Application No: A/46/21/OUT
Site Address: Land at Downs Way/Heathfield Avenue Downs Way East Preston BN16 1AB
Description of works: Outline application with all matters reserved for the erection of a pair of one and a half storey semi-detached dwellings with vehicular access, private amenity space & landscaping.

Thank you for your internet representation made on 8th April 2021 which has been recorded as an objection with the comments as follows:

Tree Protection Plan

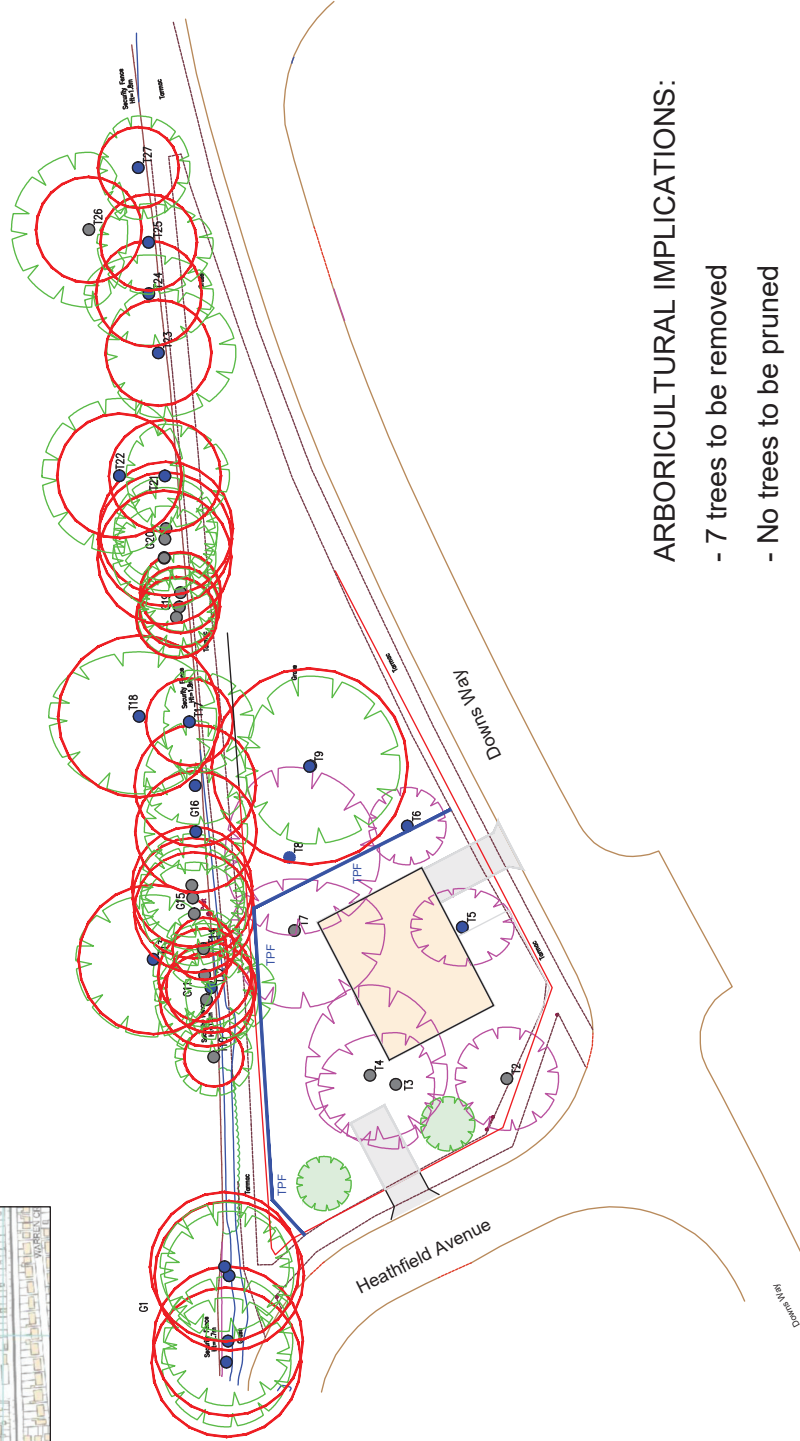
The trees on this piece of land are absolutely beautiful, especially the blossom in spring. Are we not supposed to be planting more trees rather than pulling them down. I think it is totally unacceptable that these well established trees (about 12 not 7 as the plan implies) that have been there for decades will be replaced by just 2
